**Town & Country Planning Act 1990 (as amended)
Town and Country Planning (Development Management Procedure) (England) Order 2010 (as amended)
Application for Full Planning Permission**

Development Single storey side extension.
Location 21 Westminster Drive Aldwick

SIDE ELEVATION WEST PROPOSED 1-100.

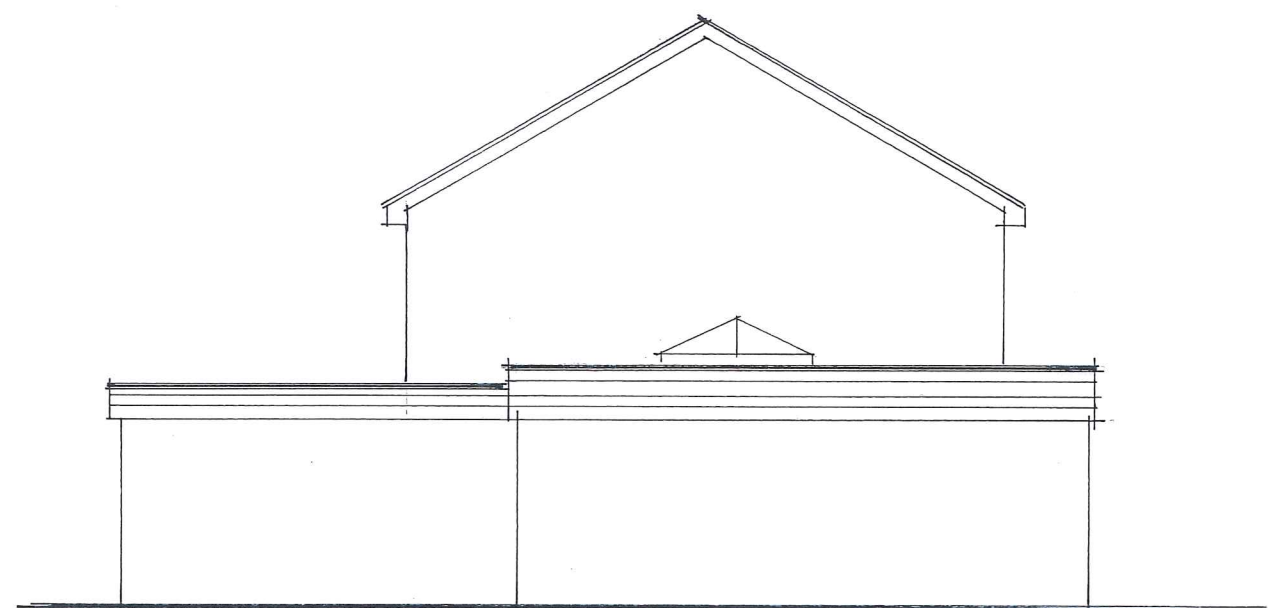
The proposed East and West elevations have not been labelled properly. Please amend accordingly.
